Planning Application: 3/2025/0377

**Prior approval for the proposed change of use of a former agricultural building to one dwellinghouse under Schedule 2, Part 3 Class Q of the GPDO.
Fields Farm, Mearley**

Planning Officer
Historic Environment Team

drawing number
ex.01

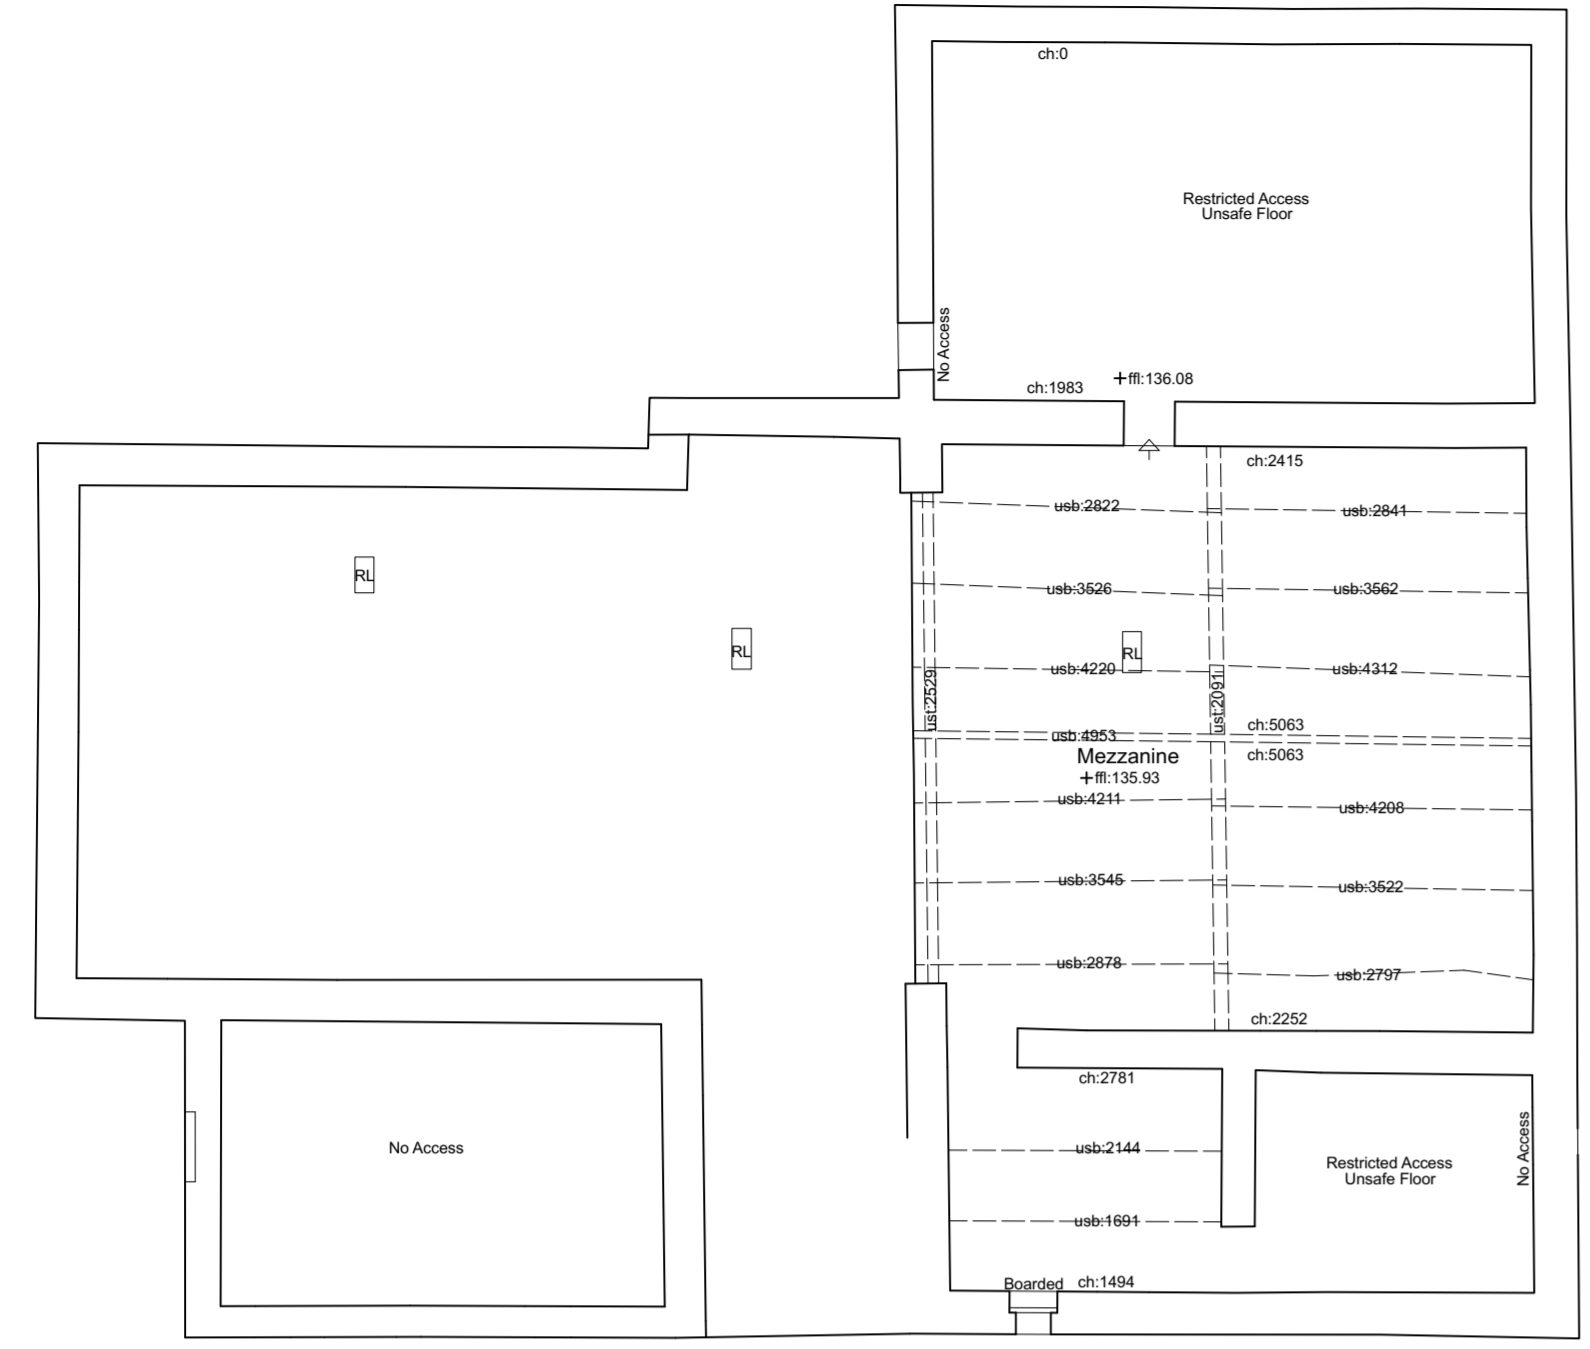
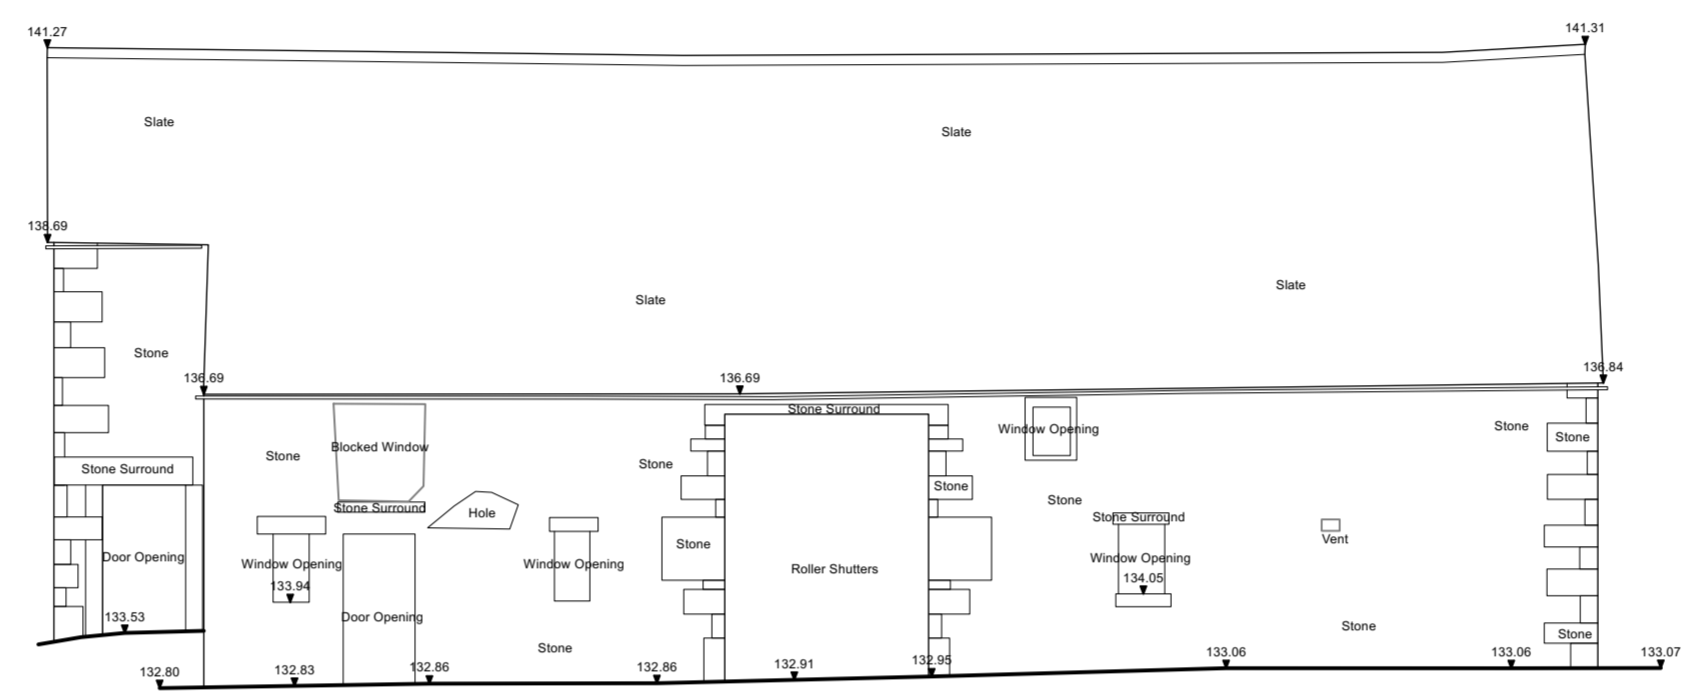
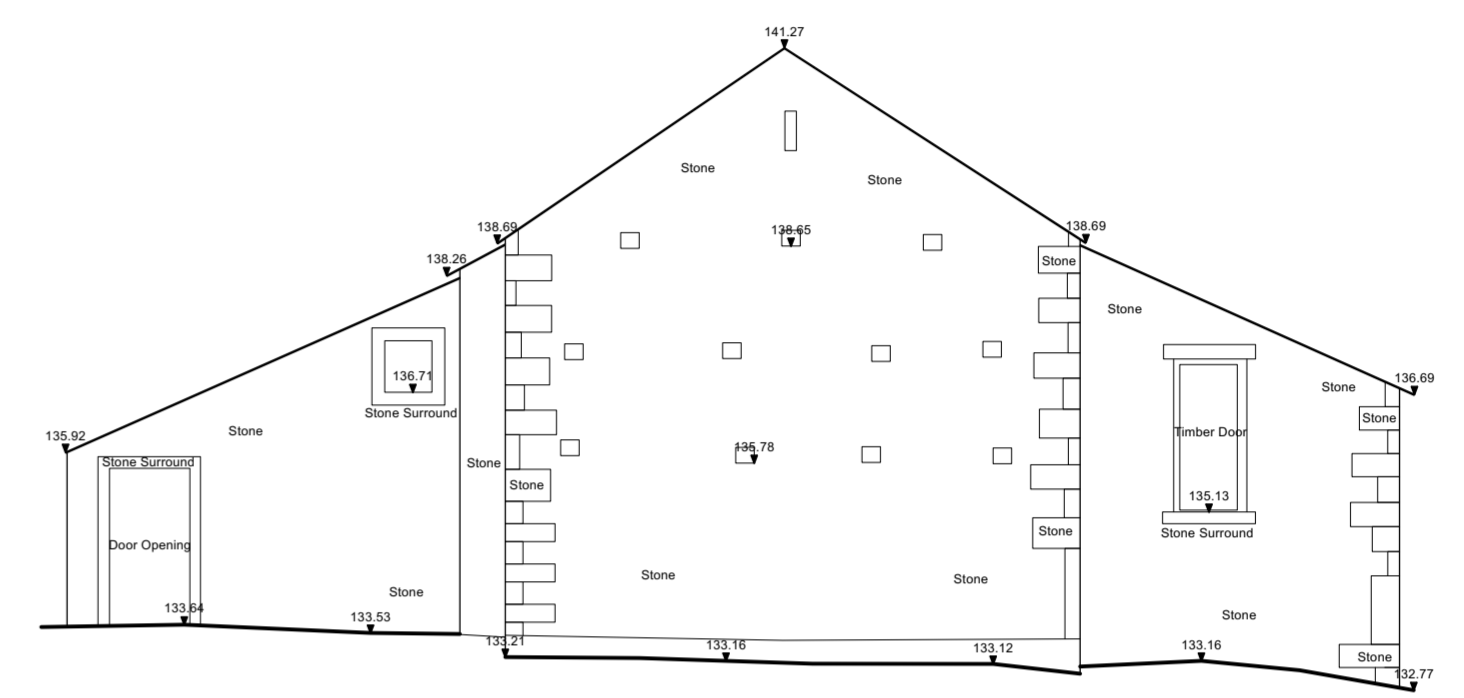
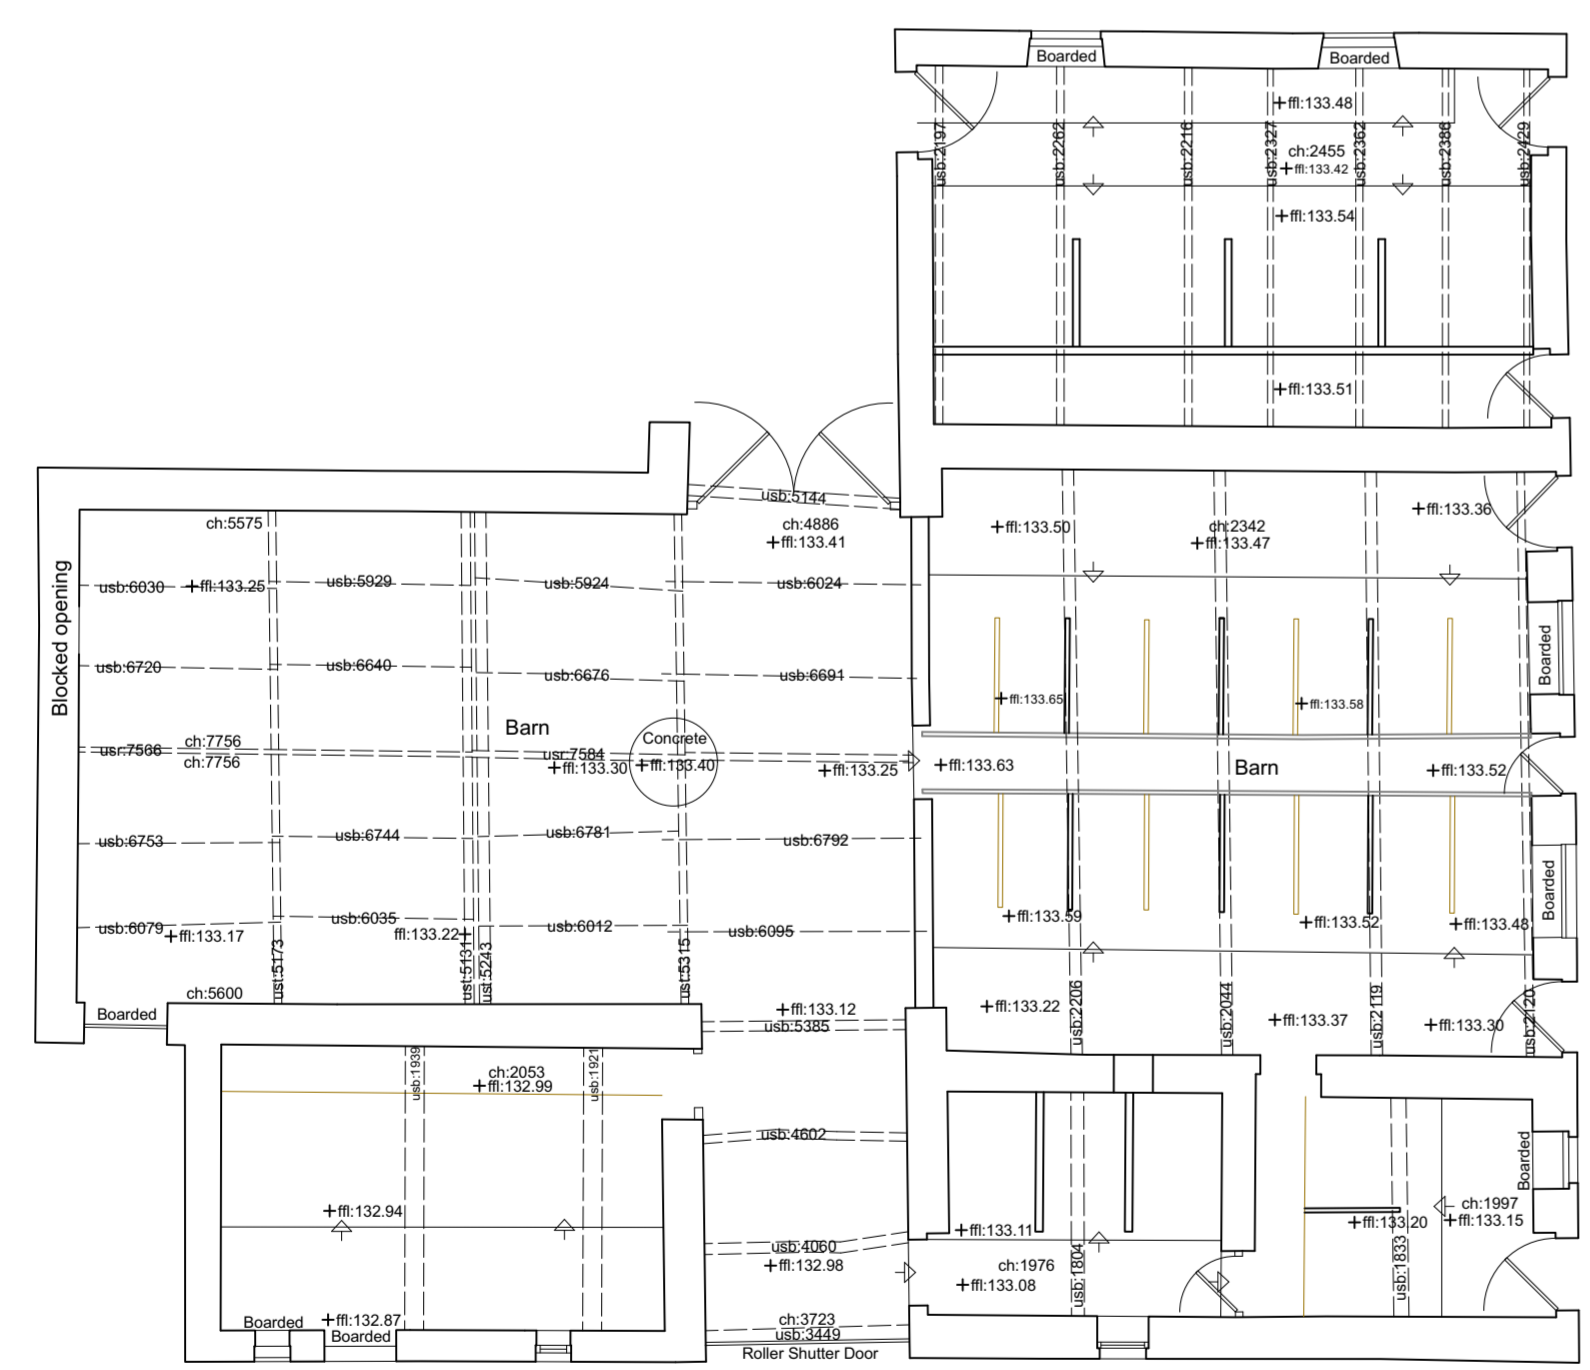
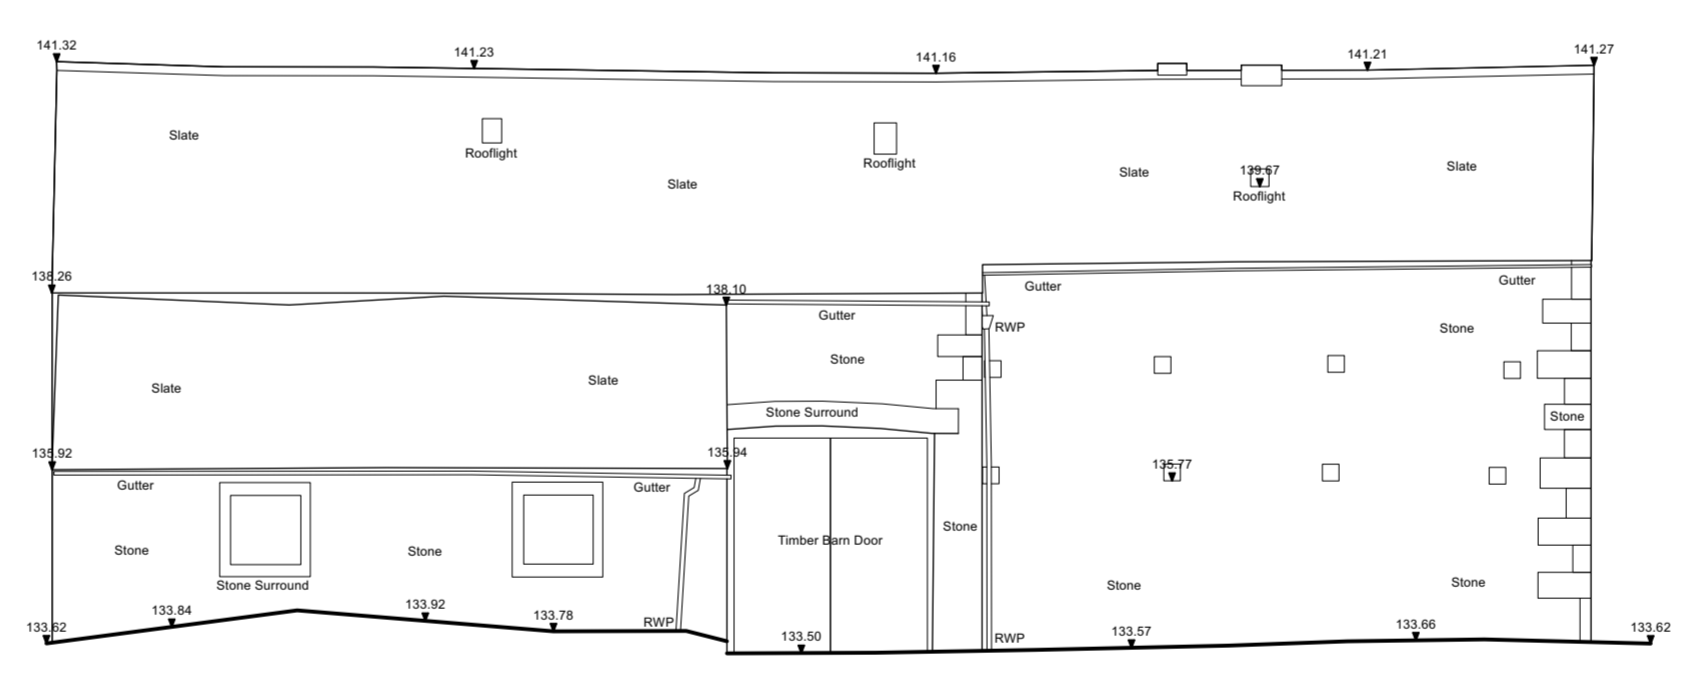
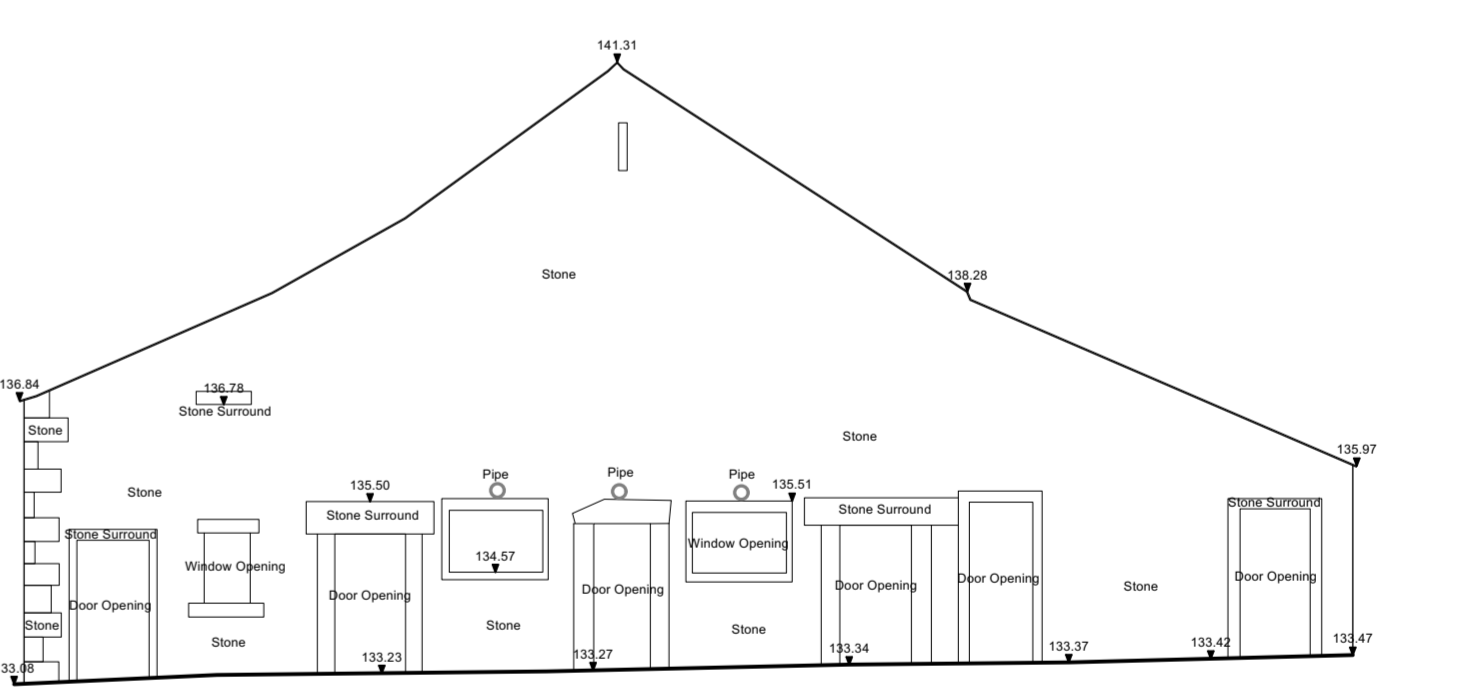
The alterations proposed will have a significant impact on the historical character and appearance of the building and may result in the loss of some historic fabric. The period 1750-1880 has been recognised as the most important period of farm building development in England.

The HET would therefore advise that should the Local Planning Authority be minded to grant consent to this scheme, a formal building record be made of the building before any works commence. This should comprise a Level 2-3 drawn, written and photographic survey, as set out in '*Understanding Historic Buildings ...*' (Historic England 2016). This can be required under the provisions of paragraph W (13) of the GPDO: "*The local planning authority may grant prior approval unconditionally or subject to conditions reasonably related to the subject matter of the prior approval.*"

Condition: No development including any demolition works shall take place until the applicant or their agent or successors in title has secured the implementation of a programme of building recording, analysis and reporting work. This must be carried out in accordance with a written scheme of investigation, which shall first have been submitted to and agreed in writing by the Local Planning Authority. The programme of works should comprise the creation of a record of the building to level 2-3 as set out in "Understanding Historic Buildings" (Historic England 2016). It should include a full description of the building, inside and out, drawn plans, elevations and at least one section (which drawings may be derived from checked and corrected architect's drawings), and a full photographic coverage, inside and out. The record should also include a rapid desk-based assessment, putting the building and its features into context. The work must be undertaken by an appropriately qualified and experienced professional contractor to the standards and guidance of the Chartered Institute for Archaeologists. A copy of this record shall be submitted to the Local Planning Authority and the Lancashire Historic Environment Record before the dwelling hereby approved is first occupied.
